WEST SUSSEX COUNTY COUNCIL CONSULTATION

TO:	Arun District Council FAO: Maria Tomalova
FROM:	WSCC - Highways Authority
DATE:	14 October 2019
LOCATION:	Abergail, Clyde Road, Felpham, PO22 7AH
SUBJECT:	FP/218/19/PL Detached block of 4 x garages.
DATE OF SITE VISIT:	N/A
RECOMMENDATION:	Modification
S106 CONTRIBUTION TOTAL:	N/A

PROPOSED GROUND FLOOR PLAN

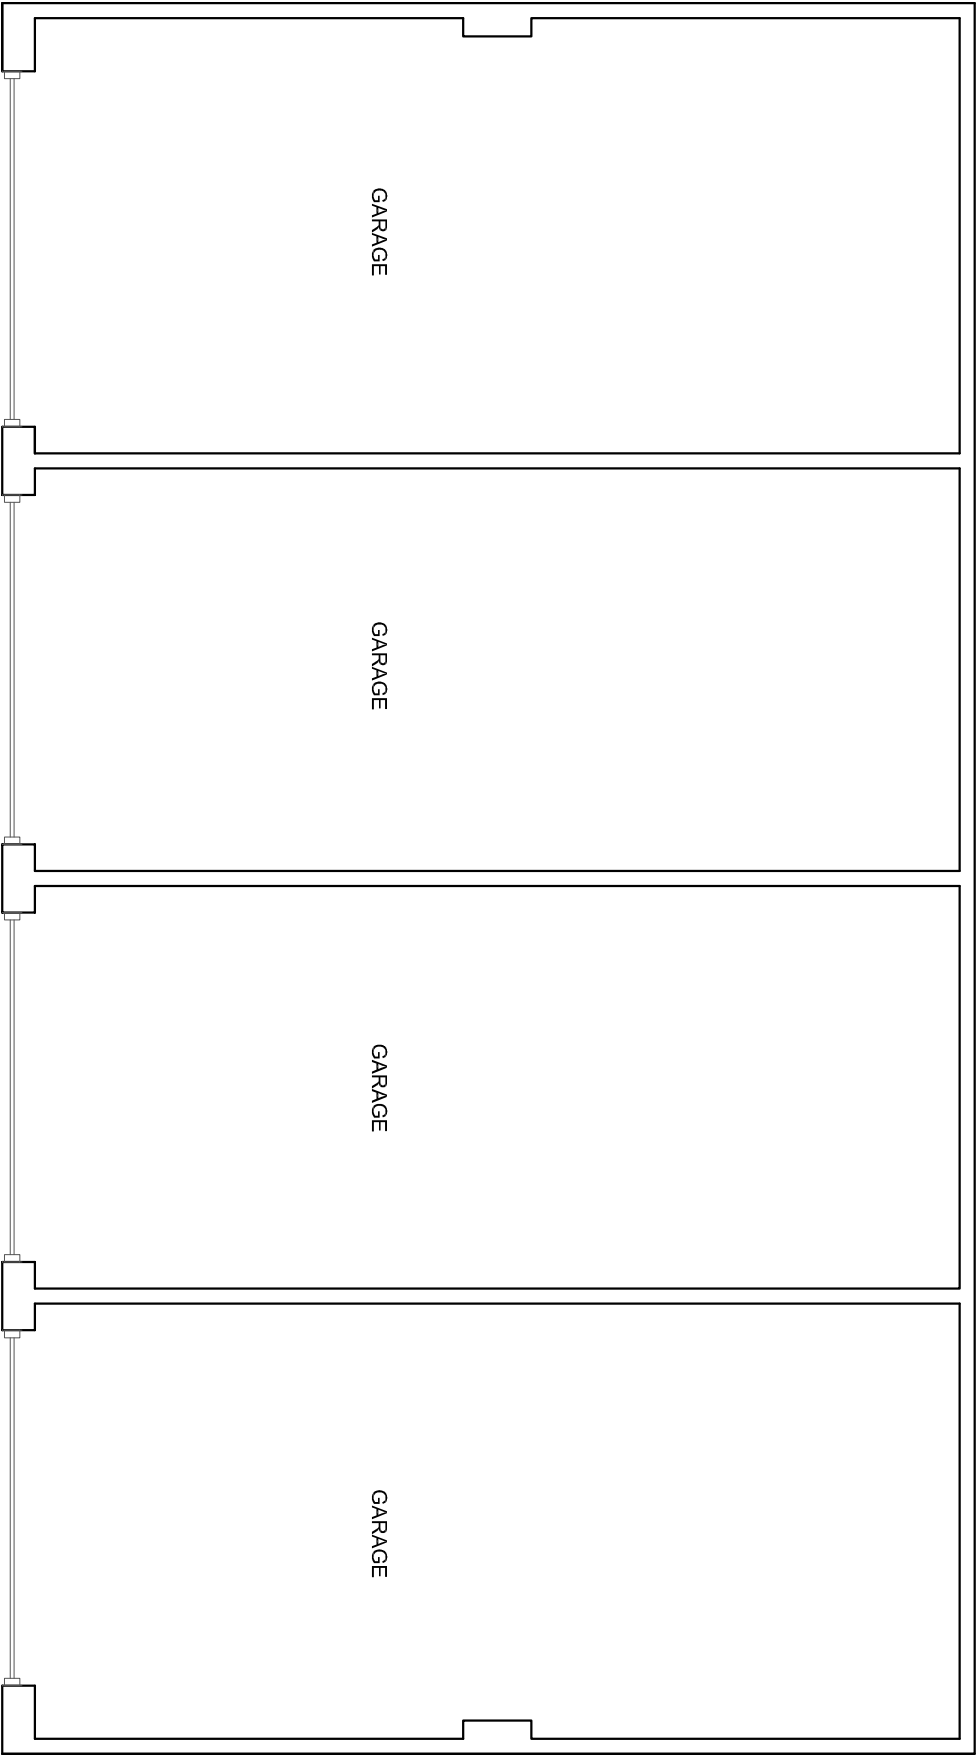
4 garages have been demonstrated in the plans, with the outer 2 garages having approximate internal dimensions of 2.88m x 6.12m and the middle 2 garages measuring approximately 2.66m x 6.12m.

WSCC parking standards for single car garage spaces are 3m x 6m of internal floor space as set out in Manual for Streets (MfS). This is in order to suitably cater for an average sized vehicle and also allow space for cycles. Cycles are commonly placed within garages for storage and whilst the nature of these garages is not directly associated with a dwelling, it is not unreasonable to consider they will be used in a similar way.

The LHA requests that the proposed plans are modified to meet MfS specifications. Once the additional information has been provided, please re-consult.
